January 24, 2024

RE: Responses to Technical Review 1
White Barn Brown Bear Car Wash
8907 & 8915 Soper Hill Rd
City File No. PA23-021
Our Job No. 22681

Letter from City of Marysville dated December 5, 2023

# PRELIMINARY LANDSCAPE PLAN

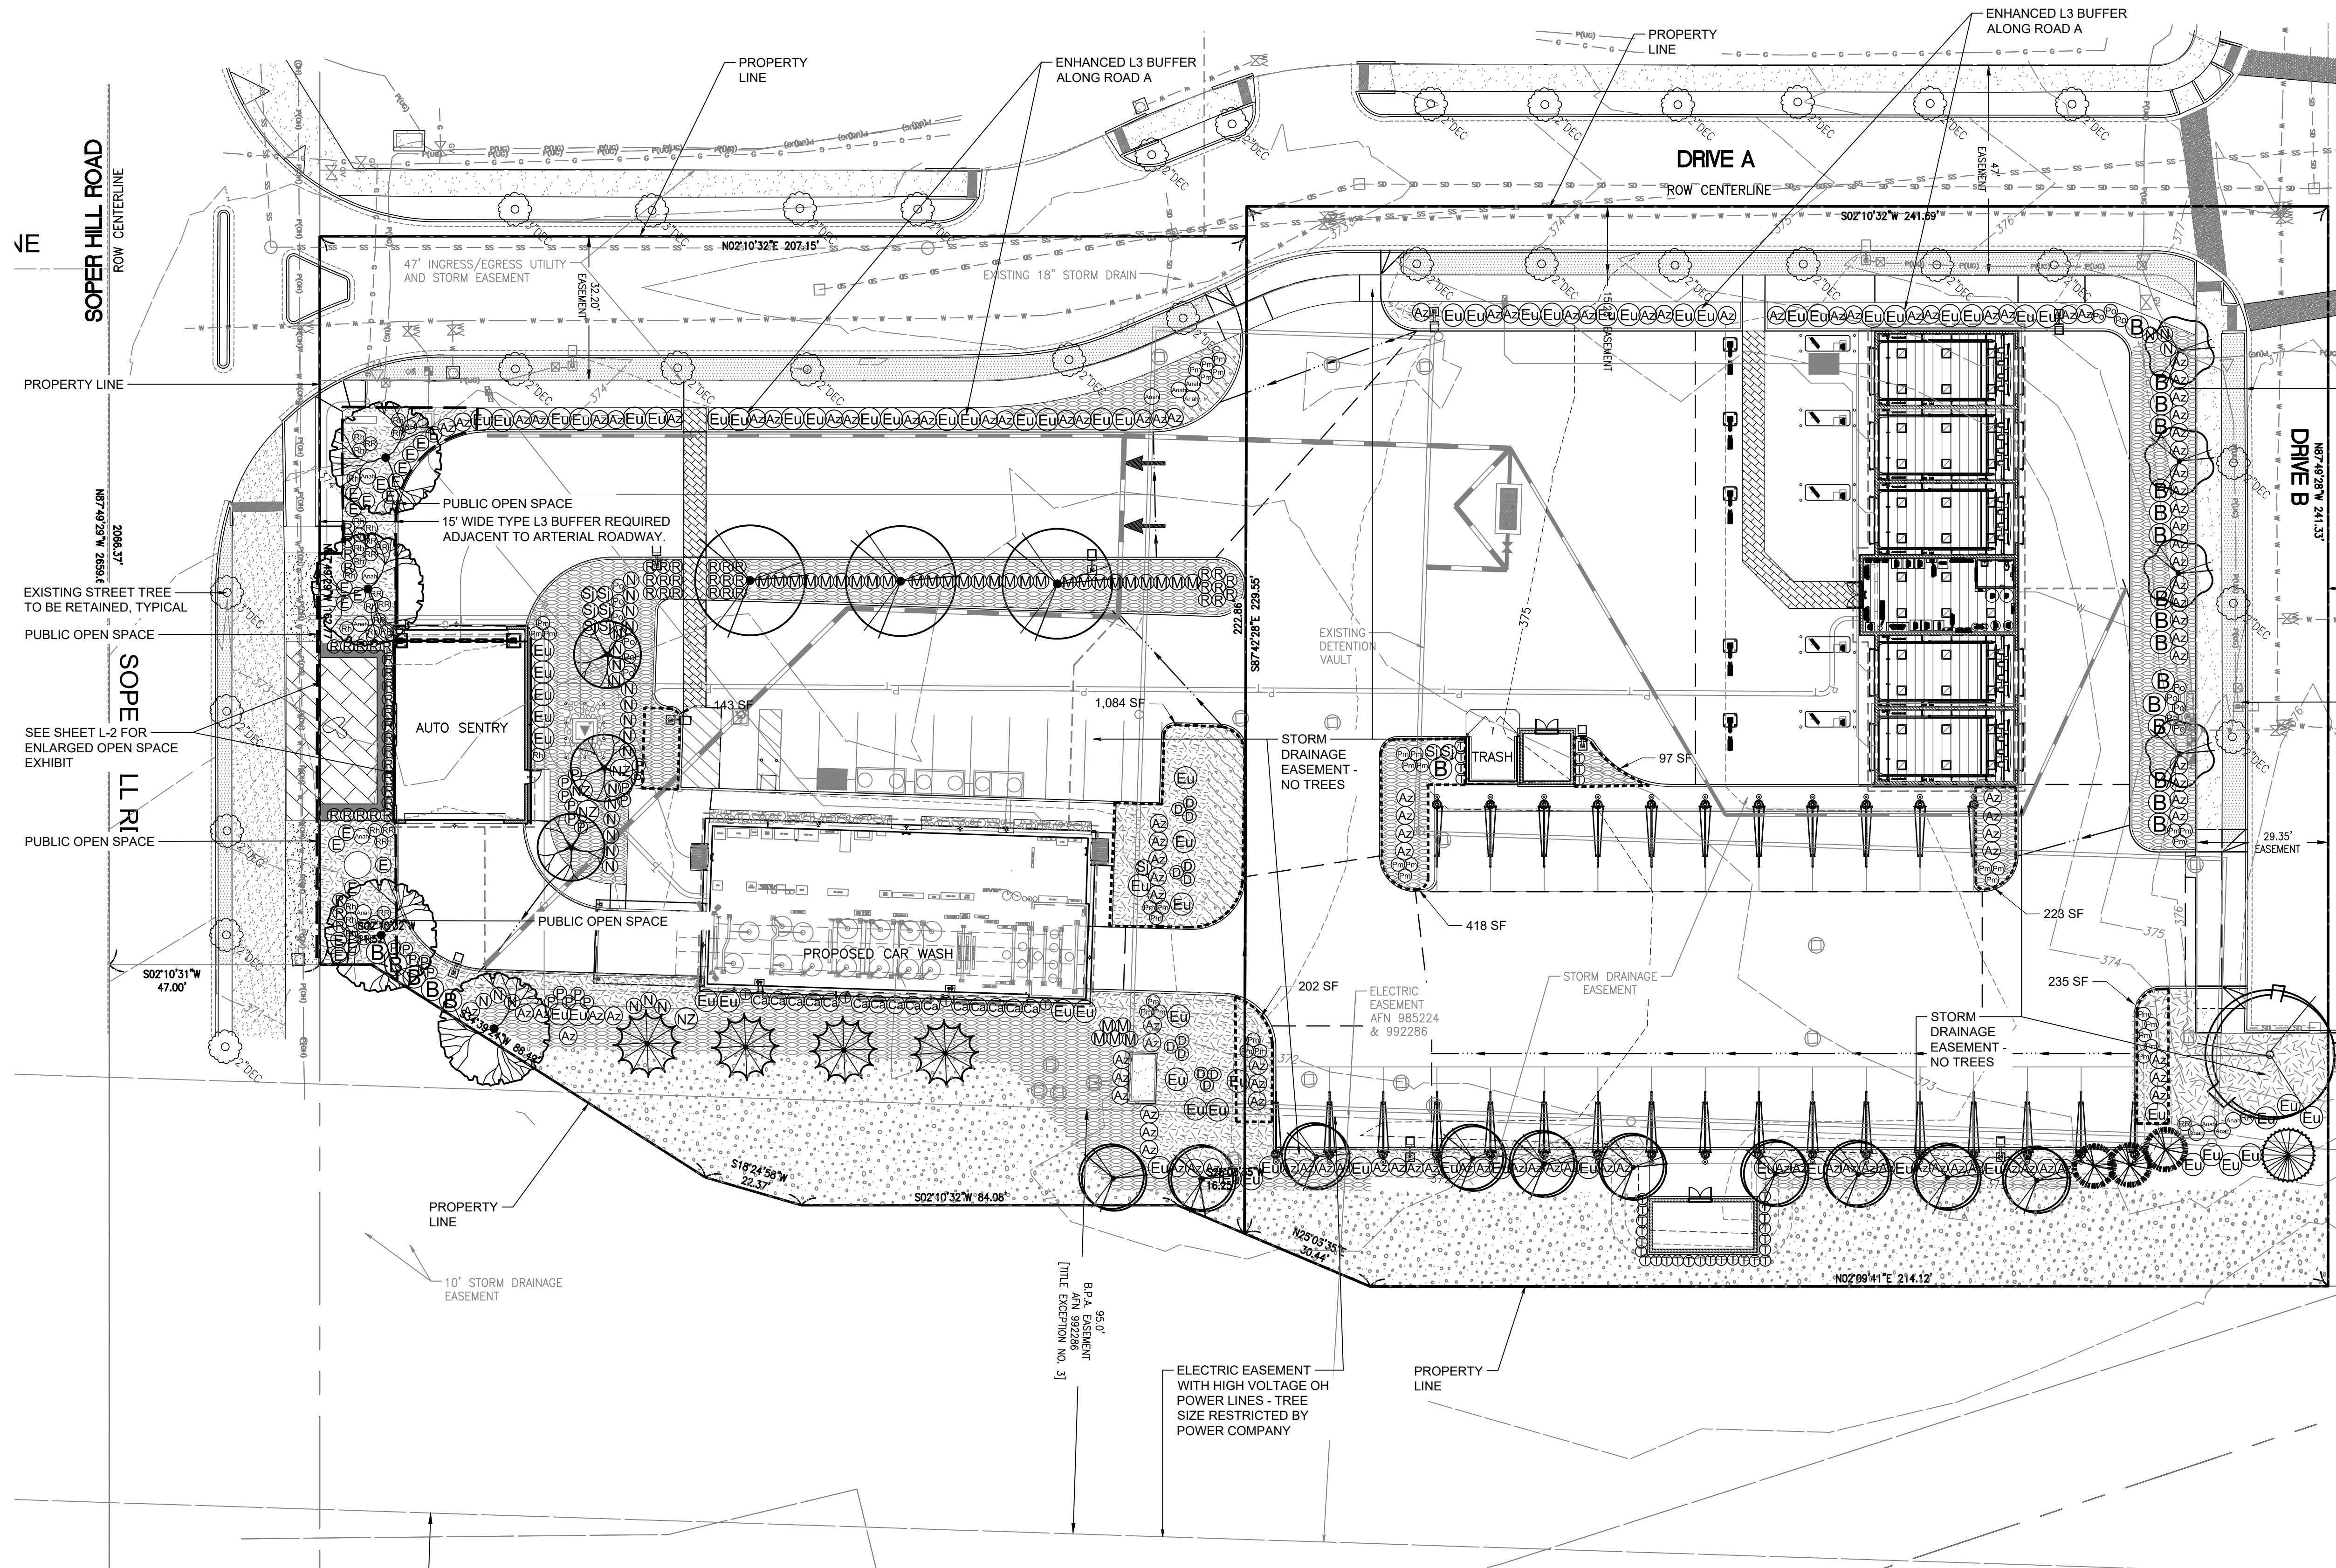
6. *Pursuant to MMC 22C.070.210(2)(a)(ii), parking lots adjacent to internal roadways must provide a 20 ft. landscaped planting strip to provide screening. Because the western boundary is for parking and vehicle queueing, adequate screening is required. Per section (iv) of the*

previously referenced section, the director may allow deviations from this section if the alternate design meets the intent of this section. As proposed, this area would not meet the requirements.

- 7. 10 ft. buffer of L3 landscaping is required along Drive A and Drive B. The provided landscape plan does not appear to propose a buffer that would adequately meet the intent of this requirement.*

Response: Please see revised sheet L1 of the submitted preliminary landscape plans. An enhanced L3 landscape buffer is proposed in lieu of a 20 ft landscaped planting strip. Adequate screening in the form of plantings is provided, with visibility maintained above 3 feet.

Response: Please see revised sheet L1 of the submitted preliminary landscape plans. An enhanced L3 landscape buffer is proposed along Drives A and B.
